Gunnedah Solar Farm, EIS submission, Geoff Hood

It looks like in relation to the information presently available for the Gunnedah Solar Farm Development, the consultants have not done the proponent or landholders any favours by not fully accessing the flooding situation, for the Environmental Impact Statement of which people have been asked to comment

Orange Grove Road, Gunnedah
5% AEP Flood Depth
Existing Scenario

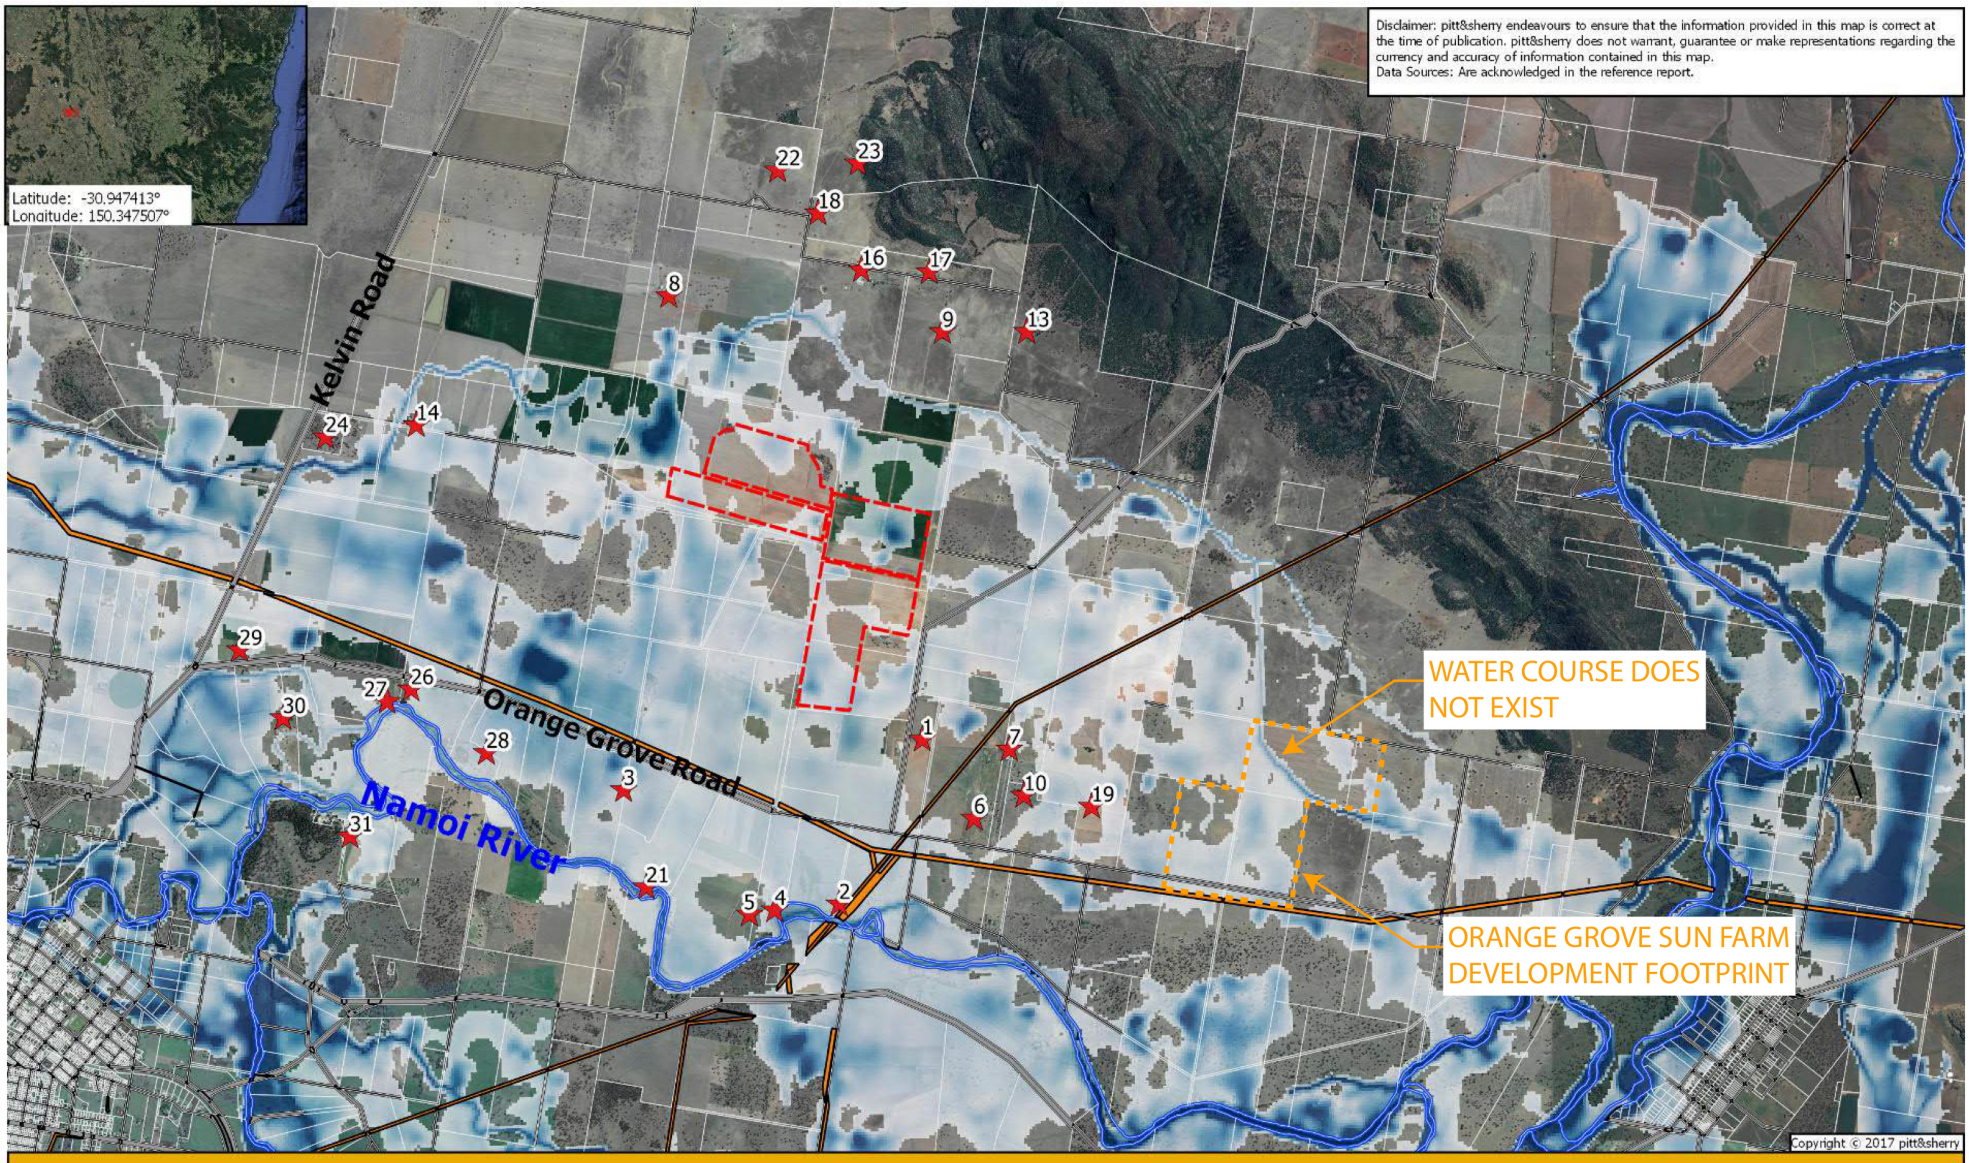
The Flood maps produced as part of the Flood Impact Assessment of the Environmental Impact Statement, appear to have inaccuracies with four areas extending towards Gunnedah that area shown as not flooded, that do. And residual flow path of water that is out by horizontally by hundreds of metres, indicating that inaccurate survey has taken place, very difficult to make long term decisions on this information

Orange Grove Road, Gunnedah
1% AEP Flood Depth
Existing Scenario

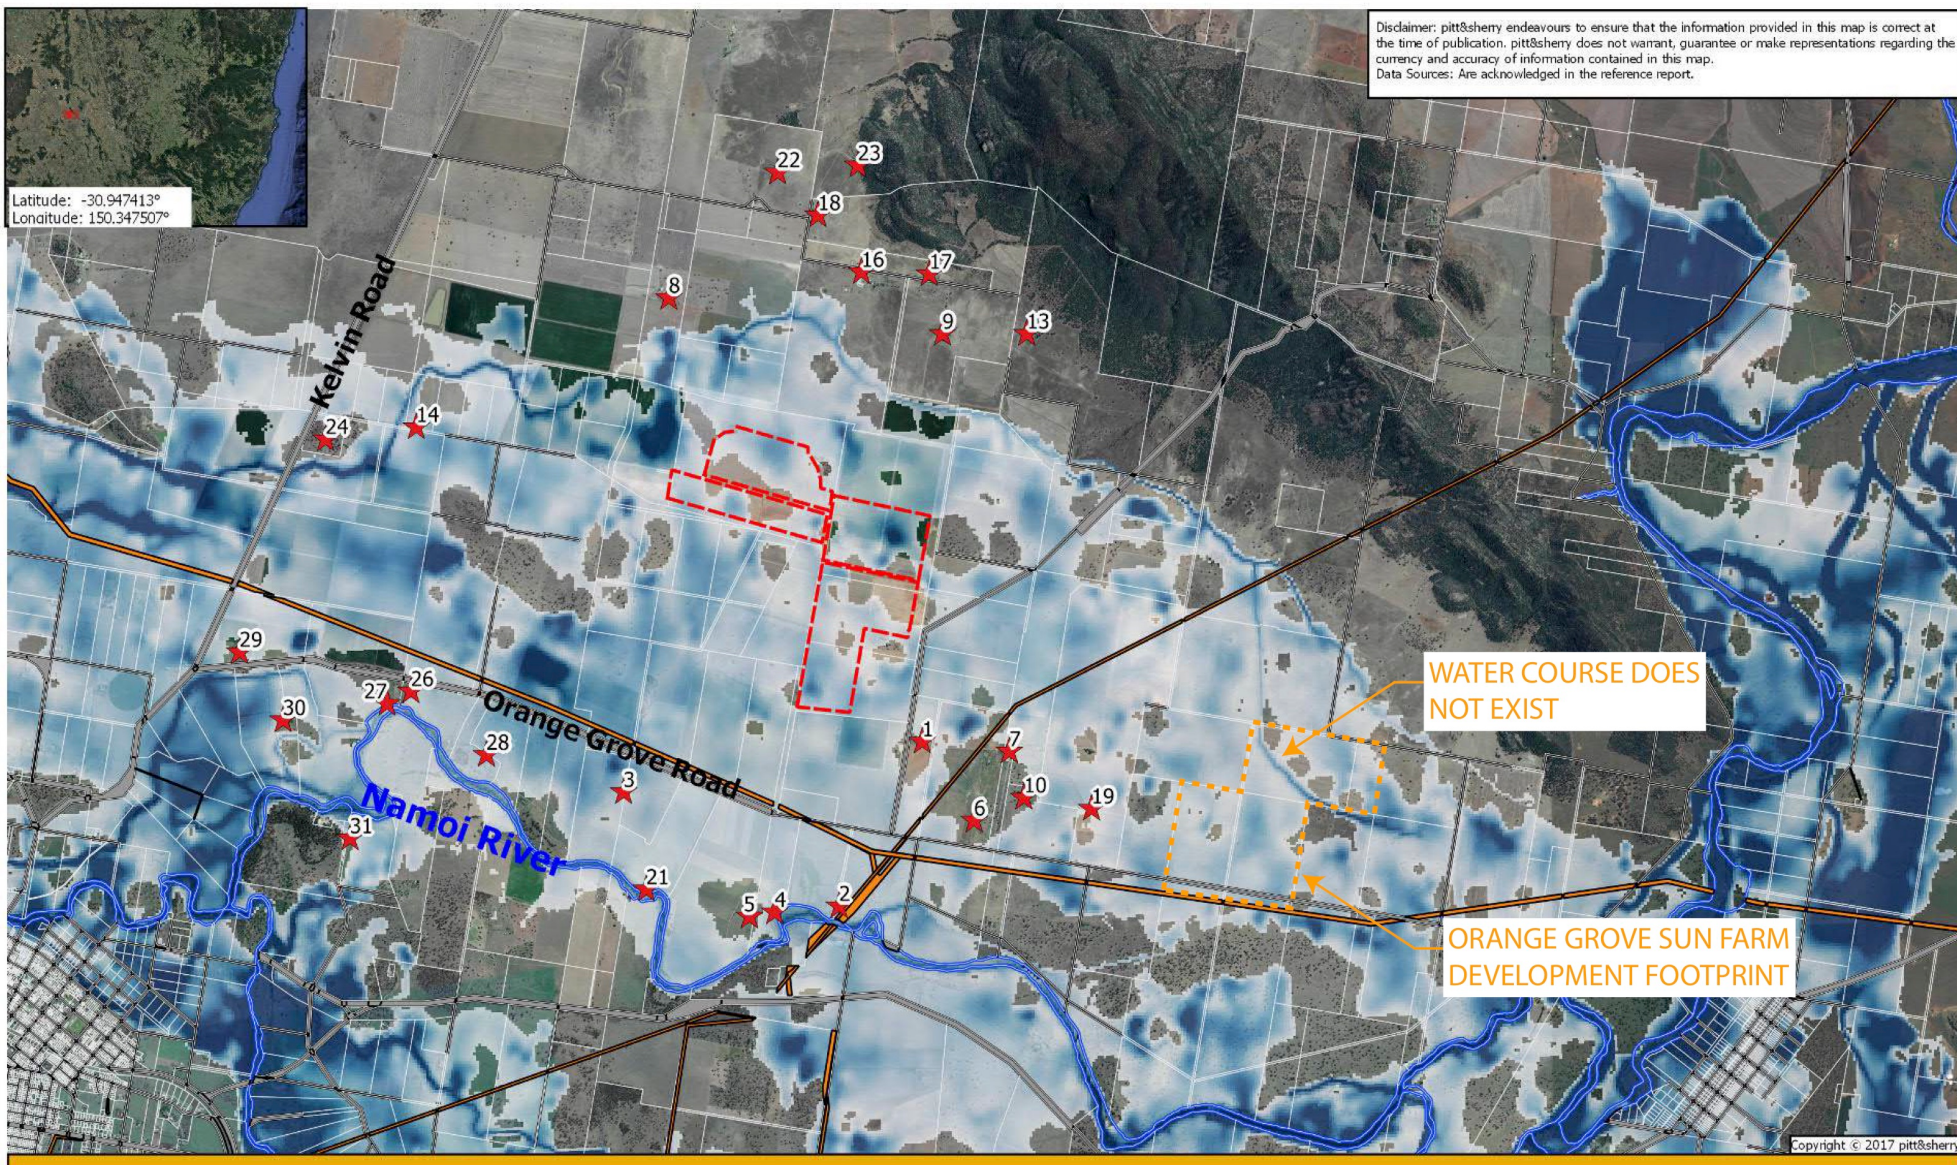
The EIS for the "Myalla" Solar farm has estimated 1/100 (1%) flood velocity at 2.1 metres /second flood flow through the solar footprint, The Carroll- Boggabri Floodplain Plan Compendium of Data (Draft for Public Exhibition -August 2005) Mike II model has the High Velocity Namoi River North Breakout at an extreme level of 4.7 metres /second across the Orange Grove Road into "Myalla" with more floodwater volume in the breakout than the Namoi River itself, the Mike 11 model then has value's lowering to 2.6 metres second once floodwaters enter "Daisy Plain"(with no development), still above the numbers estimated by Pitt/Sherry, Conversely the Mike 11 model of the Carroll- Boggabri Floodplain Management Plan, has a much reduced than estimated by the consultants, North Myalla Solar Farm footprint flood velocity, in the range Low to Moderate 0.4 - 0.6 mt/sec velocity.
